Ribble Valley Borough Council  
Housing & Development Control

Your ref 3/2021/0801  
Our ref D3.2021.0801  
Date 12<sup>th</sup> October 2021

Application no: **3/2021/0801**

Proposal: **Proposed demolition of a single storey kitchen. Construction of 2 storey side extension and single storey rear extension.**

AMENDED
PROPOSED SITE
PLAN

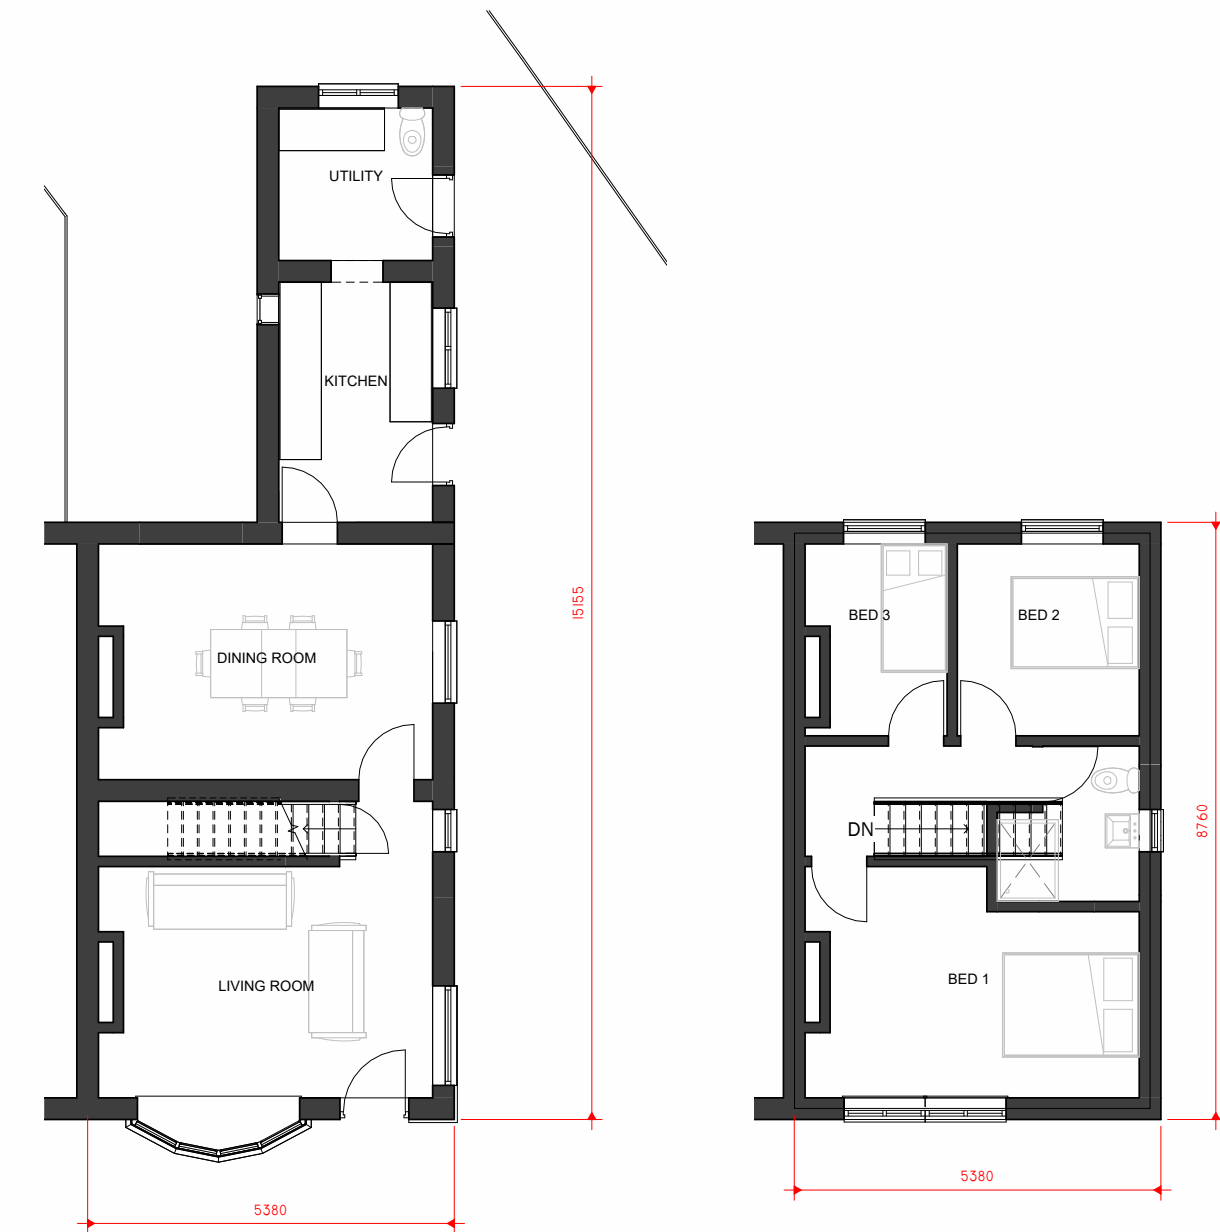
The dwelling will still remain a 3-bed property but in response to the alteration of the driveway as shown on Peter Hitchen drawing number A1.2 titled "Proposed Site Plan" the access will be altered.

The LHA have reviewed the drawing and understands that the existing dropped crossing will be widened to a length of approximately 7m wide. While, the access width more than complies with the LHAs guidance for a single dwelling, the LHA are concerned about the depth of the driveway with it now being 4.5m in length. This is contrary to the LHAs guidance titled "Code of Practice Vehicle Crossings", which requires a driveway to be a minimum of 4.8m in length for the proposal to be acceptable.

The LHA do acknowledge that the drawing does show that the 2 parking spaces provided on the driveway will be parked at an angle to the dwelling. However, the LHA are unable to accept these spaces with there being no deterrent to prevent vehicles parking perpendicular to the dwelling. This will lead to vehicles overhanging onto the footway which is detriment to highway safety.

Not only this but if vehicles are parked at an angle to the dwelling, like on the drawing, and other vehicles are parked on street adjacent to the access then it will cause a complex manoeuvre to exit the site which could cause a conflict between vehicles, especially in a reverse gear.

The first option is to fully relocate the access to the grassed area next to the neighbouring dwelling called Lingmell and remove the existing garden wall at the site. The LHA have measured the depth of the grassed area and are aware that the length is approximately 7.3m and so it complies with the LHAs guidance titled "Code of Practice Vehicle Crossings." Not only this but the area can provide 2 car parking spaces to comply with the parking standards and the access arrangements will also comply with the LHAs guidance.

The grassed area could then be relocated to the existing access at the site which will then need to be stopped up with full height kerbs.

The second option is to remove the side extension from the application and leave the access as existing with there being adequate space to provide 2 car parking spaces.
